Rezoning Transportation Analysis

Petition Number: 2021-112

Date	Description
09-21-21	First Review (BKB)
11-29-2021	Second Review (PDM)
01-27-2022	Third Review (PDM)
03-24-2022	Fourth Review (PDM)

RZ-2: PARCEL IDENTIFICATION PLAN

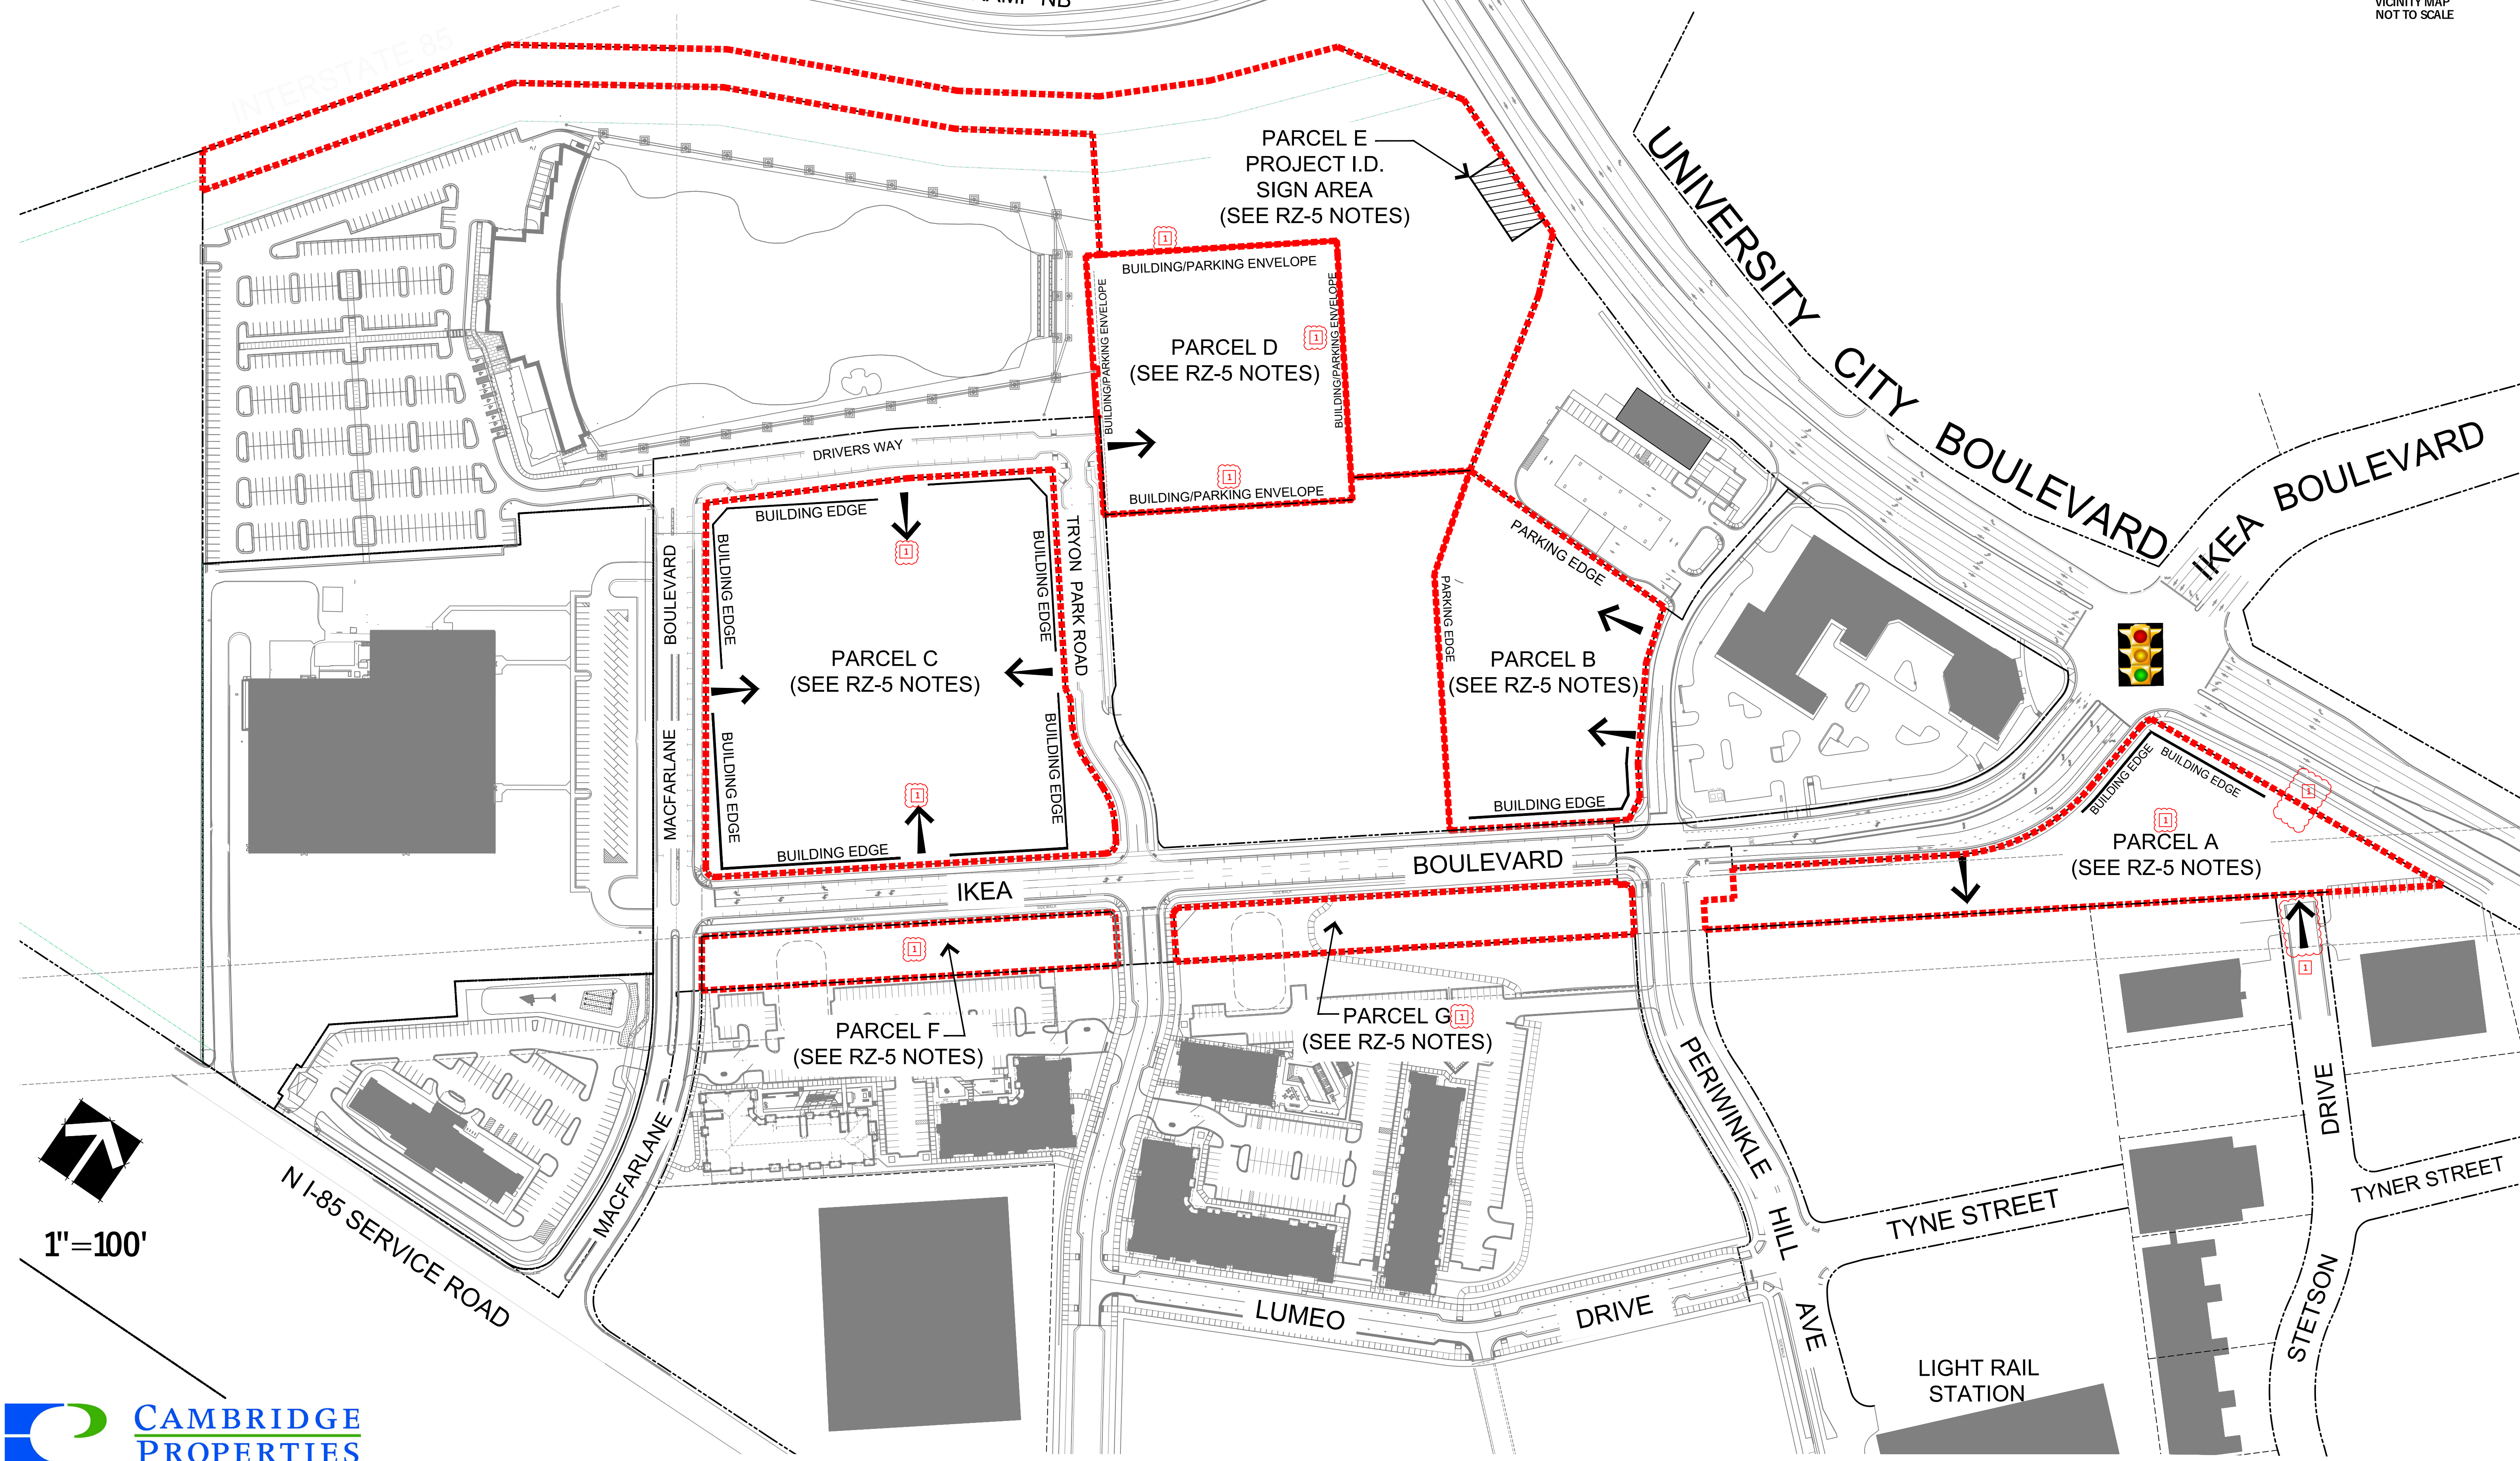
~~2. Access points are not permitted off of University City Boulevard. Revise site plan and general notes to reflect the access point to Parcel A being off Stetson Drive as opposed to the currently shown access point on University City Boulevard.~~

RZ-2: PARCEL IDENTIFICATION PLAN

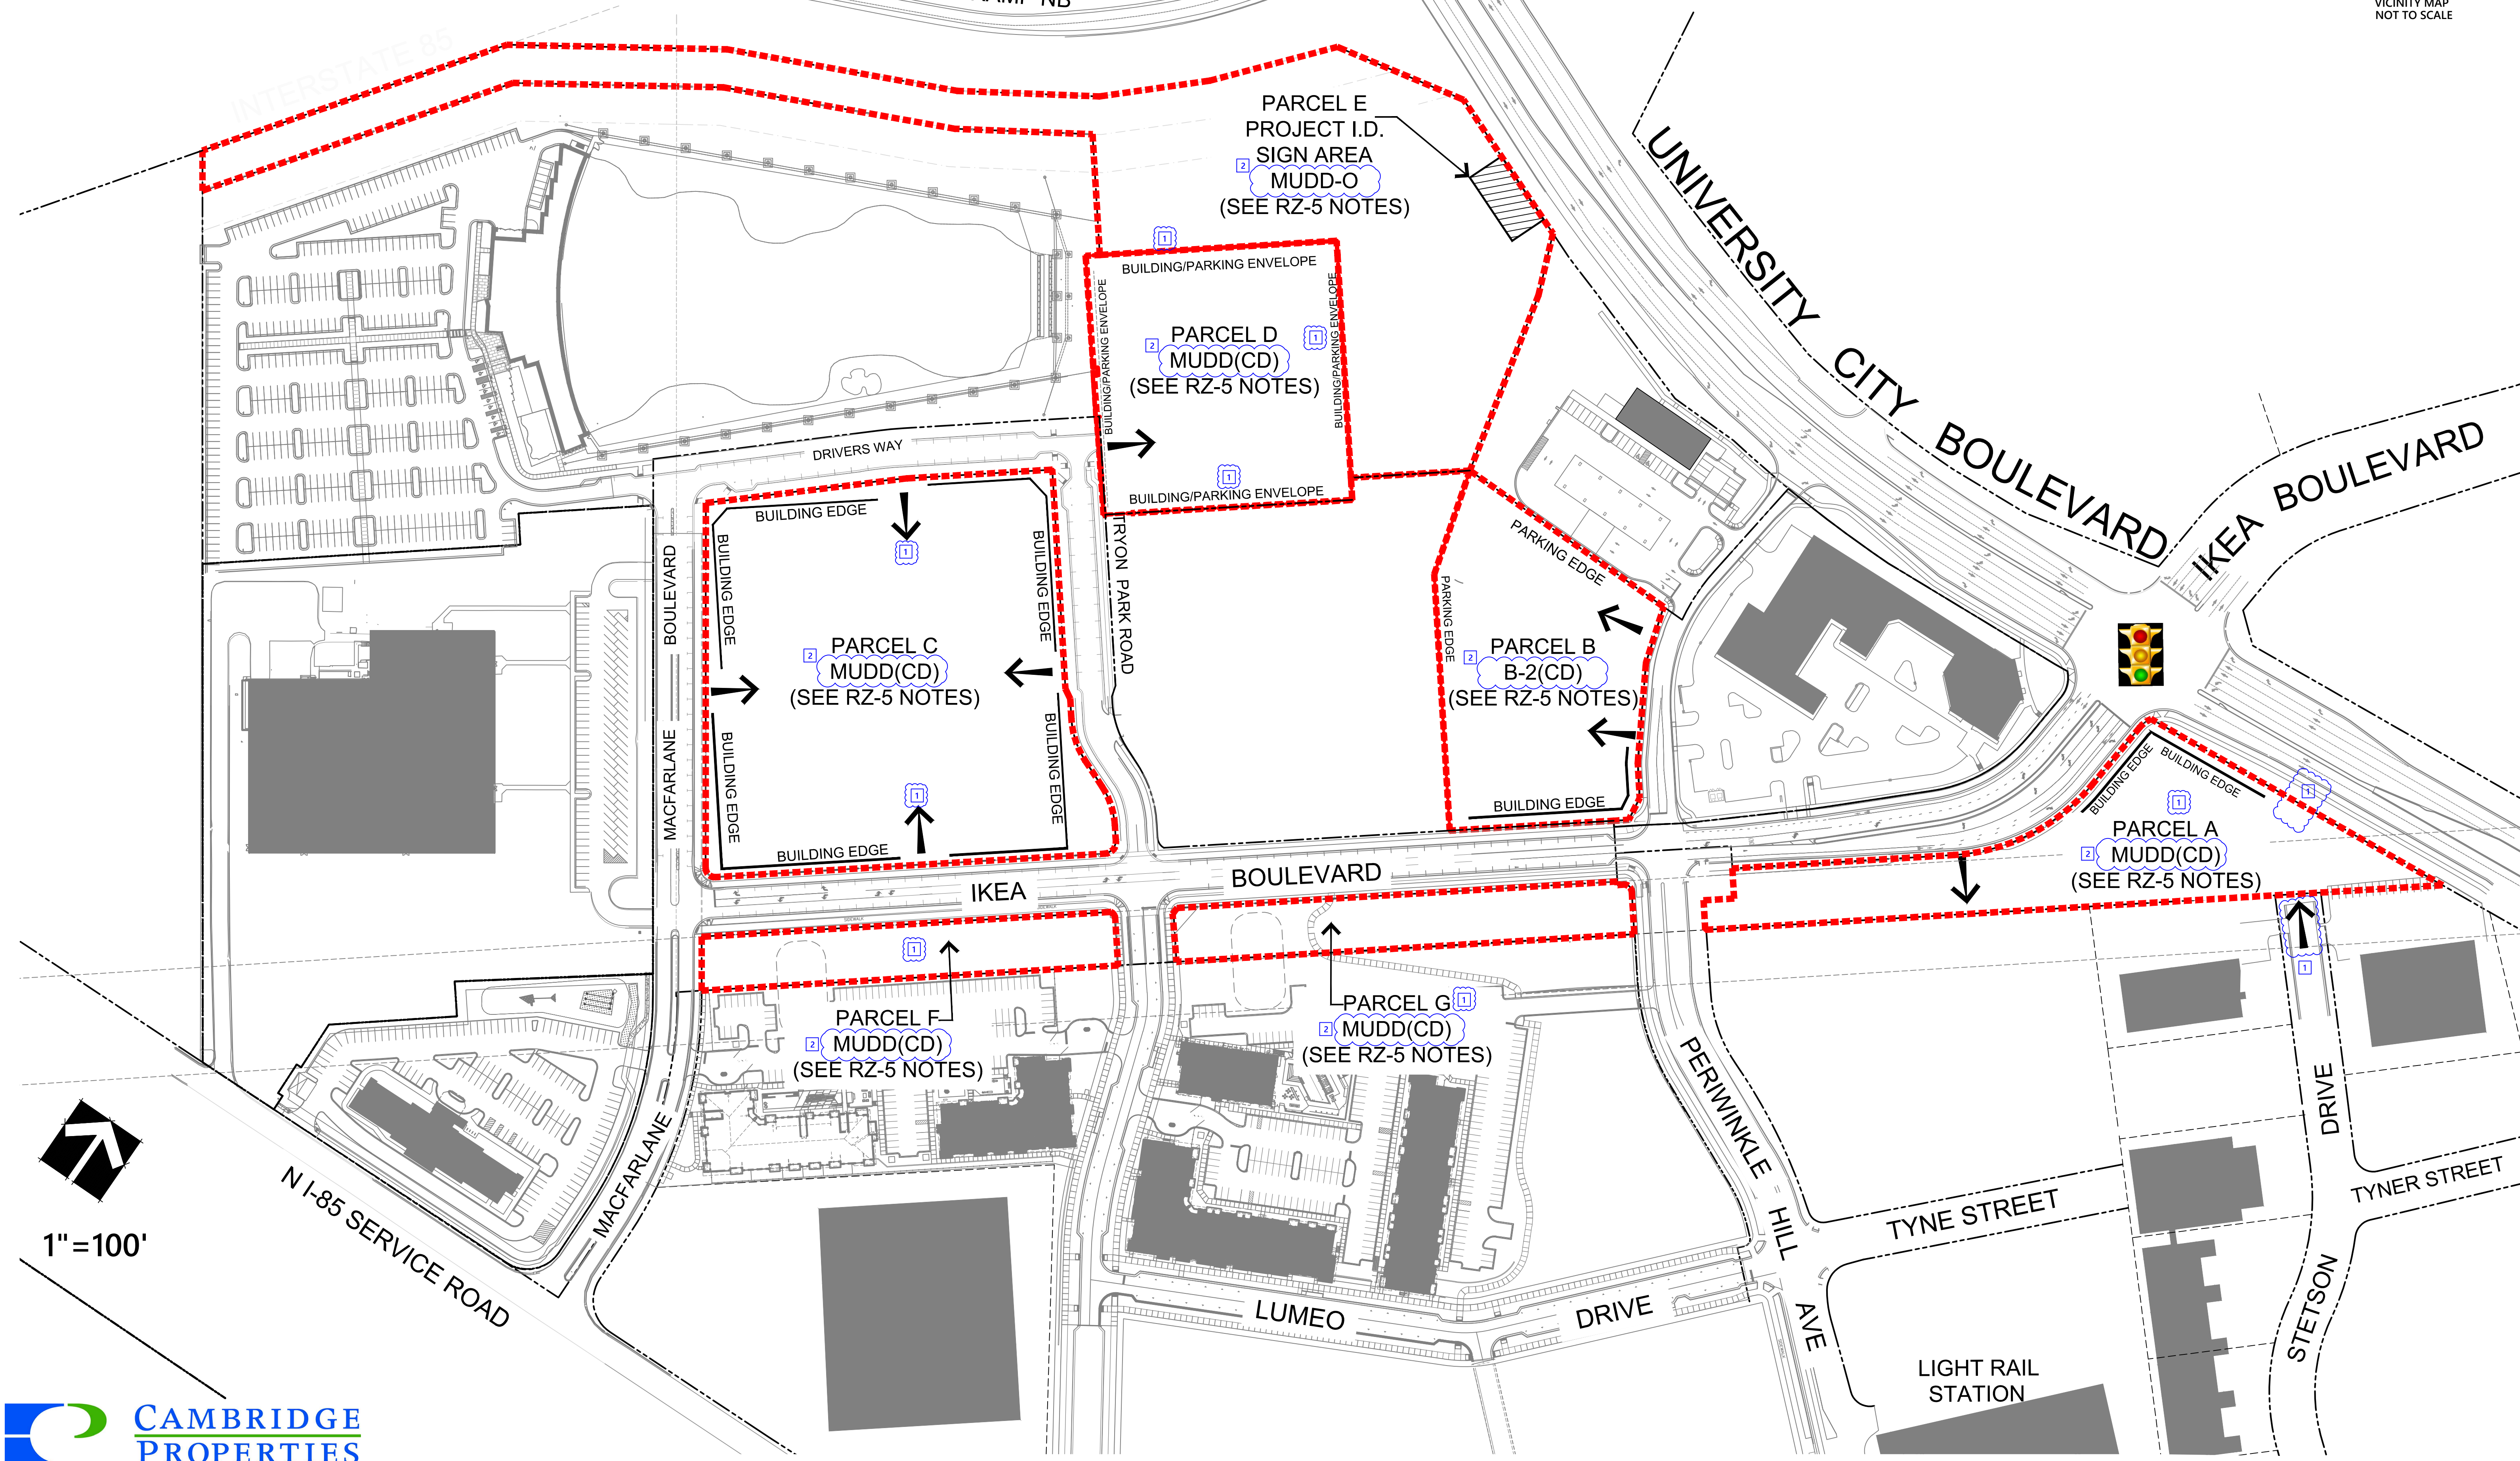
5. **New Comment 3.24.2022:** Revise site plan and conditional notes to commit to installing 8-foot planting strip and 8-foot sidewalk along all public road frontages with no existing sidewalk or along road frontages where the sidewalk is substandard per Chapter 19 ordinance.

6. **New Comment 3.24.2022:** A site plan note(s) specifying dedication and fee simple conveyance of all rights-of-way to the City before the site's first building certificate of occupancy is issued as needed. CDOT requests rights-of-way set at 2' behind back of sidewalk where feasible.
